**From:** Sarah Burrow <Sarah.Burrow@arun.gov.uk>  
**Sent:** 14 February 2022 08:20  
**To:** Planning.Responses <Planning.Responses@arun.gov.uk>  
**Cc:** Harry Chalk <Harry.Chalk@arun.gov.uk>  
**Subject:** RE: Planning Consultation on: BN/6/22/DOC

#### **Engineers Comments Regarding Surface Water Drainage**

**Application No:** BN/6/22/DOC  
**Registered:** 24th January 2022  
**Site Address:** Russet Cottage Highground Lane Barnham PO22 0BT  
**Description of Works:** Approval of details reserved by condition imposed under BN/154/20/HH relating to conditions 4-surface water drainage scheme & 5-as built drawings of implemented scheme.

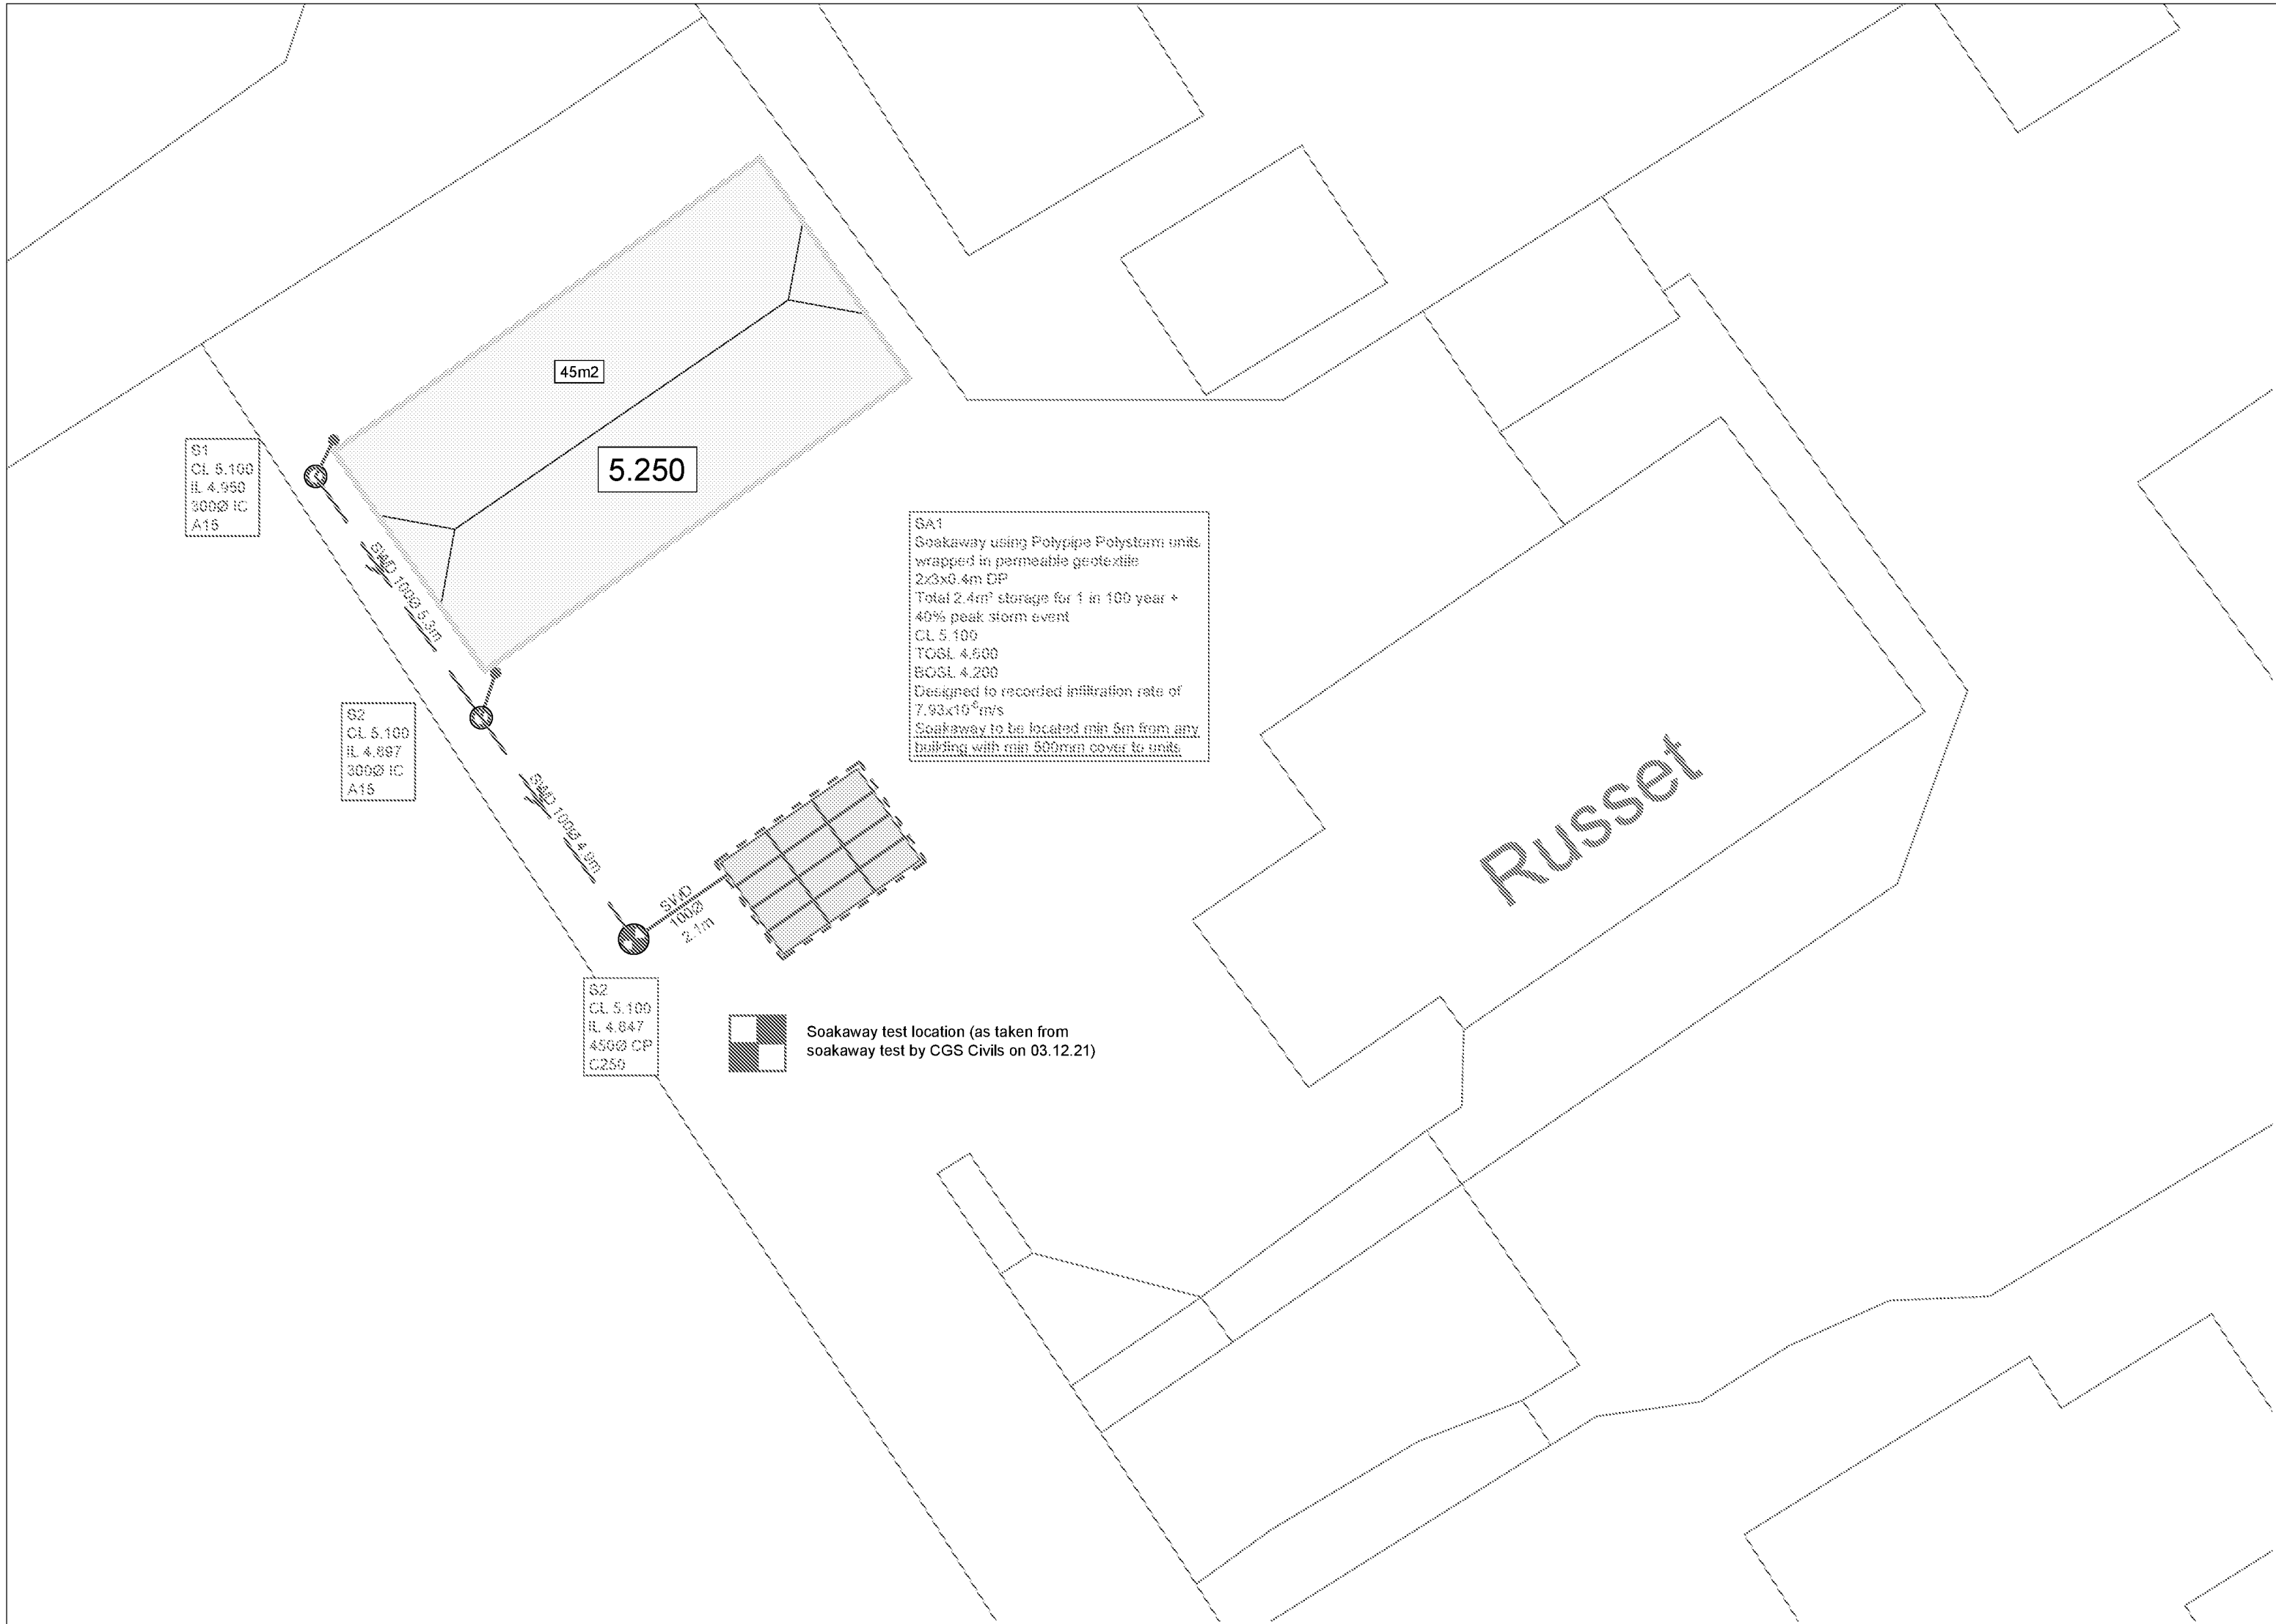
It is recommended that this condition is discharged. All surface water drainage is to be constructed in accordance with 'Surface water Drainage Layout' Drawing 'C1981-P-100-P'.
